Planning Officer: Simon Davis
Planning Application Ref: **AW/259/18/PL**
Location: **10 Barrack Lane, Aldwick, PO21 4BZ**
Description of works: 1 No. dwelling

Mark Warwick

Tree Officer / Parks and Greenspace Team

10 Barrack Lane, Bognor Regis - 'No Dig' Construction Typical Section

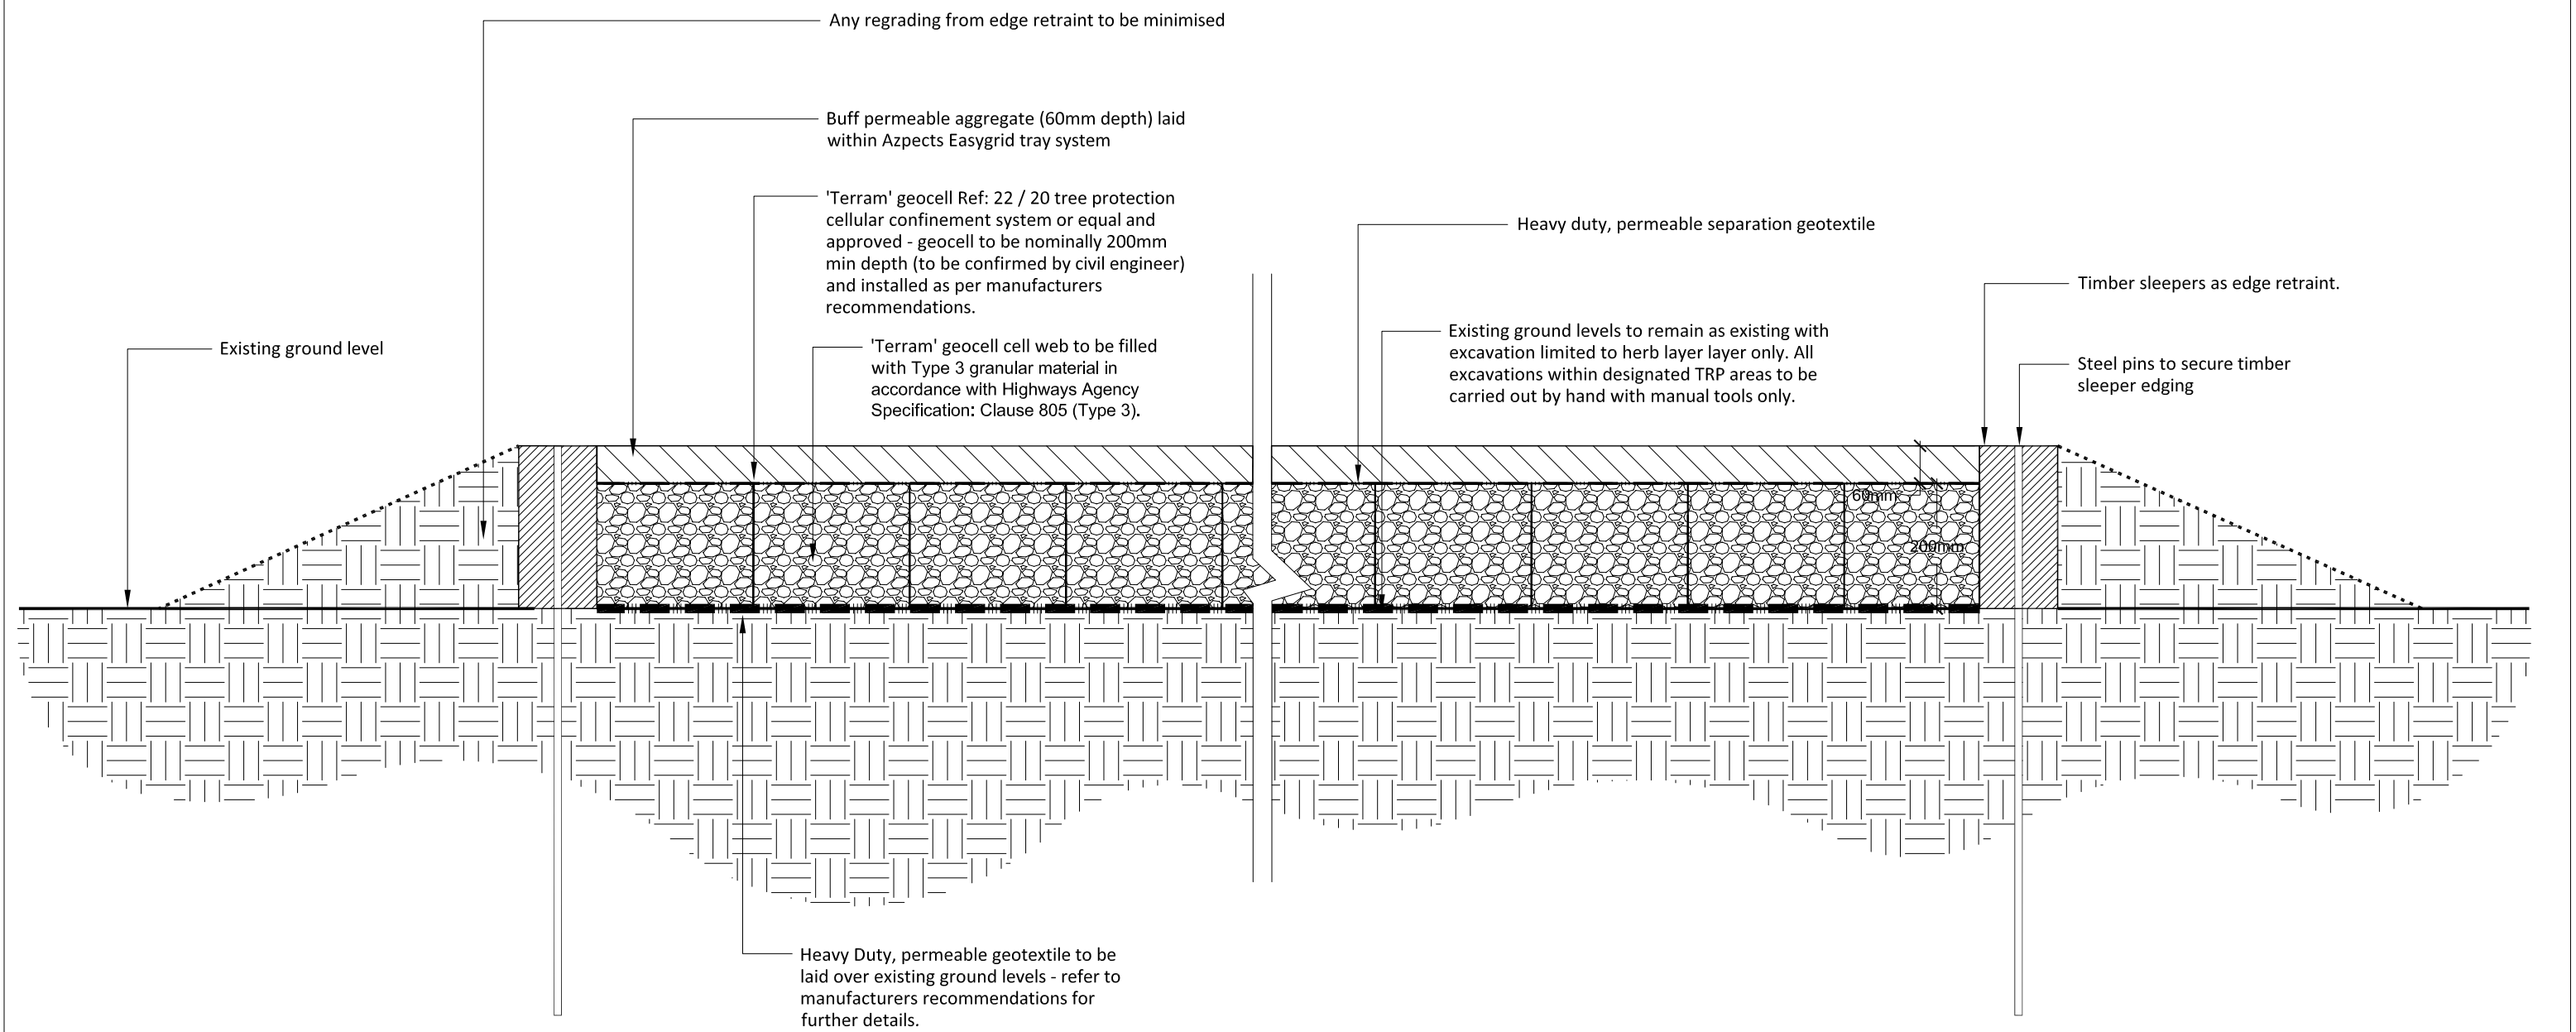
2. There is not enough detail in the specification for the *No-dig solution*, which is especially important in this instance as it is proposed to be in place prior to any demolition/construction and must therefore have load bearing capability sufficient to support construction traffic. I have not seen any detail in relation to materials/timing of installation for the hard wearing surface, which must be permeable.

- In the absence of being able to locate the dwelling further south and therefore outside the RPA of T03; ground protection measures must be put in place at the same time as installation of tree protection fencing. This ground protection would exist across the RPA between fencing and building footprint as currently shown on the aforementioned drawing – which will need to be revised to show the same.
- I would like written confirmation from the engineer providing the cellular confinement system (*No-dig solution*) that it will have sufficient load bearing capability to endure the entire phase of development and retain sufficient integrity so as to accept a permeable hard wearing surface (as yet unspecified).
